From: Eve Hearsey [REDACTED]
Sent: 16 May 2014 14:19
To: Simon Davis
Subject: AL/26/14 - Response to Private Sector Housing & Public Health Team Consultation Response.

I note that there are comments back from the above department regarding one of the properties within the application AL/16/14, namely Cart Barn. I would like to respond as follows.

FLOOR PLAN 1:50
CART BARN

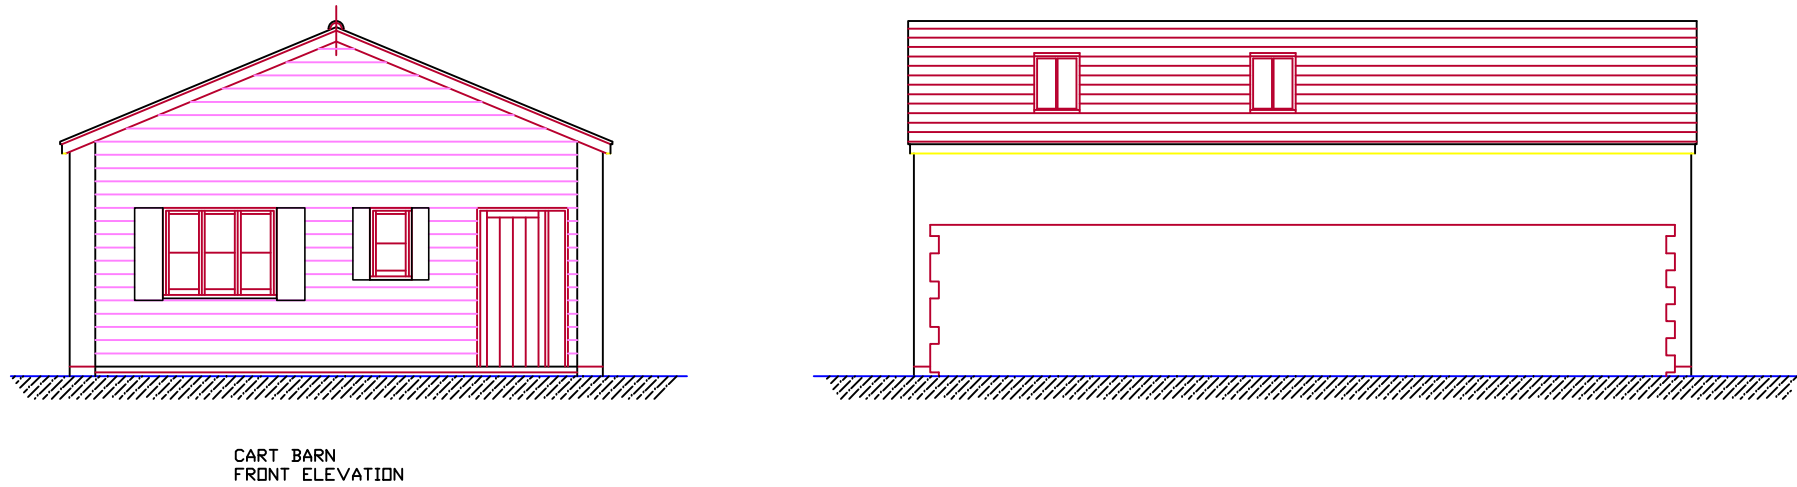
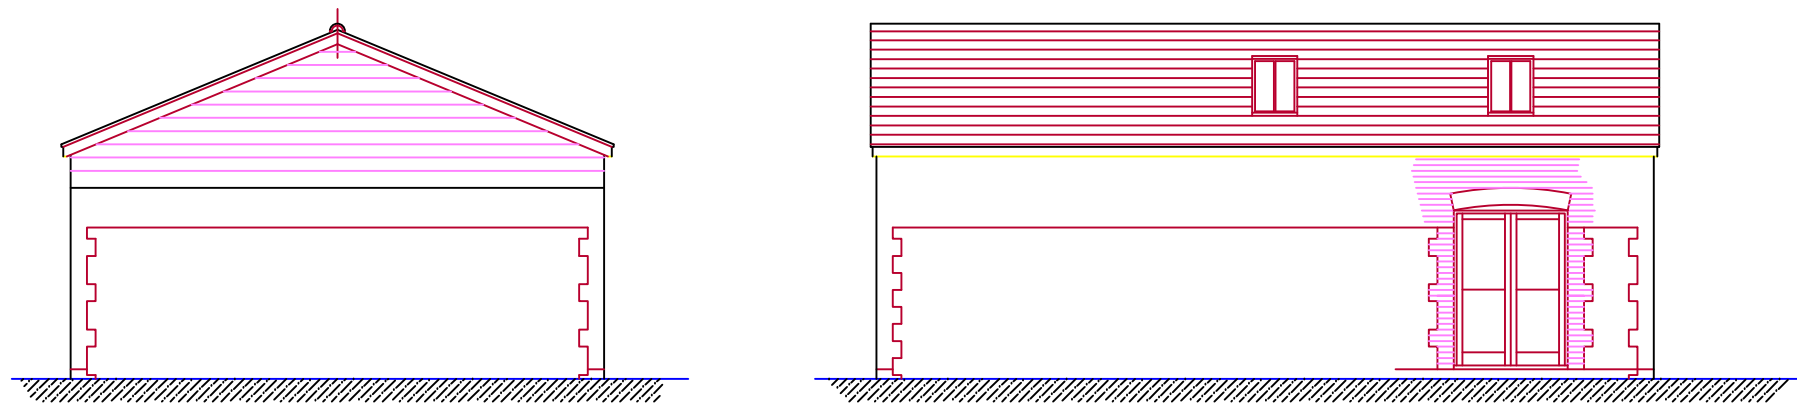
Excluding the openable doors, there are 4no. rooflights, each one measuring 750mm x 550m = 0.4125 square metres each x 4 = 1.65 square metres

The floor area of the Kitchen/Lounge/Diner = 38.19 square metres, therefore 1/20th of that area = 1.91 square metres.

1.91 sq. m. - 1.65 sq. m. = 0.26 sq.m ventilation shortfall.

Thereby the only shortfall by the workings of the in house consultation response would be 0.26 sq.m within the Kitchen/Lounge/Diner

However, if the glazed front door was to be converted to include a half light that would be 1m x 300mm = 0.3 square metres, that figure added to the existing total of the Kitchen/Lounge/Diner of 1.65 sq.m. would make a new total of 1.95 square metres which would result in no shortfall.

Full glazed door, $1.8 \times 1.3 = 2.34$ sq. m. + Rooflights 1.65 sq.m + Glazed front door panel, 2m x 300mm = 0.6 sq. m = Total 4.59 square metres

1/10th of the 38.19 sq.m floor area of the Kitchen/Lounge/Diner = 3.819 square metres - No shortfall.
